Development Control  
Ribbles Valley Borough Council

**App no: 21.0951**

**Address: Land at Higher Standen Farm and Part Littlemoor Farm Clitheroe**

**Proposal: Discharge of Conditions 30 (Play Space Management Plan), Condition 54 (Footpath and Cycle Way), Condition 58 (Road Drainage, Fire Hydrants, Hard Landscaping, Footpath and Cycle Linkages), Condition 59 (Bus Stops) from planning permission 3/2015/0895 as updated by non-material amendment 3/2016/0939**

Title
 PHASE 2
 Proposed Highway Layout

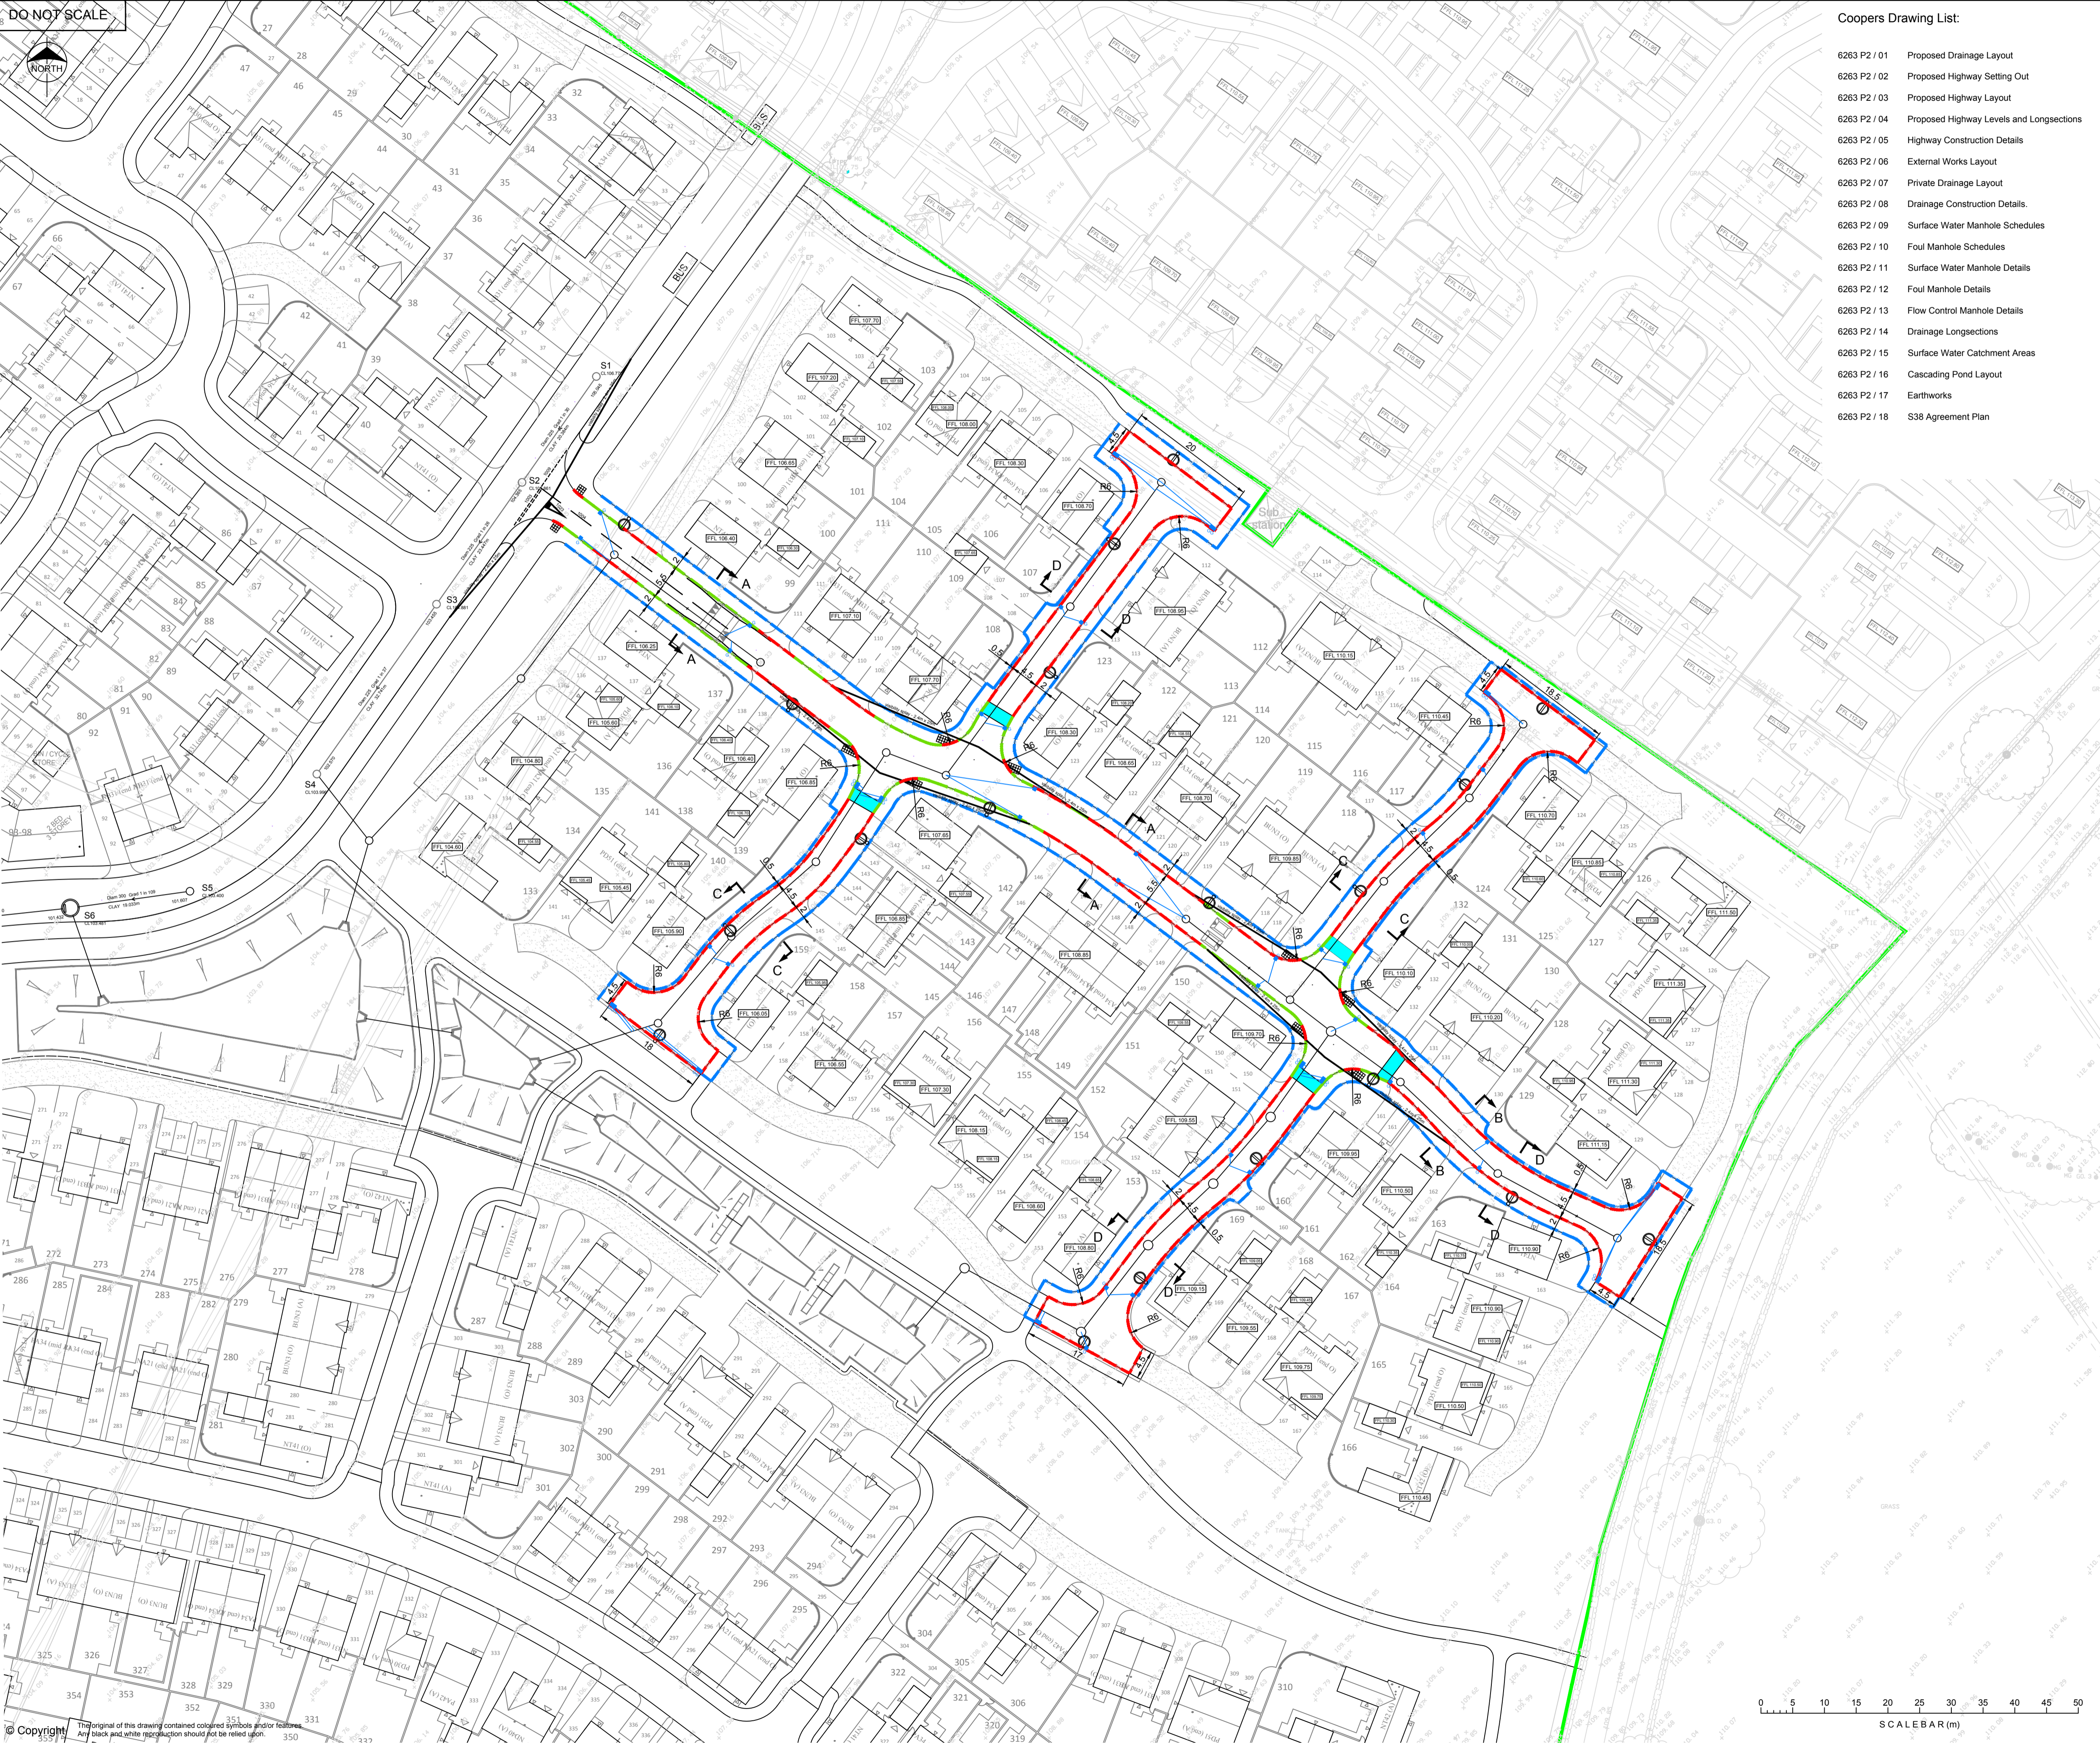
We would request that the trees and verge on both sides of the spine road are located at the back of the footway rather than between the footway and carriageway. This is to minimise the detrimental impact on the highway whilst keeping the aesthetic and environmental benefit of the vegetation within the street scene.

There will need to be controlled crossing points (zebra crossings) close to both pairs of bus stops and in the vicinity of the school and shop to assist pedestrians across the spine road.

The two pairs of bus stops shown on the drawing are acceptable. A temporary bus turning circle needs to be constructed south of the bus stops to allow the service to be diverted into the site, please submit a plan and timetable for the implementation.

As the development progresses the turning circle will need relocating to the southerly side of the most southern bus stops. This will be required until the through route is provided when the bus turning facilities will no longer be required.
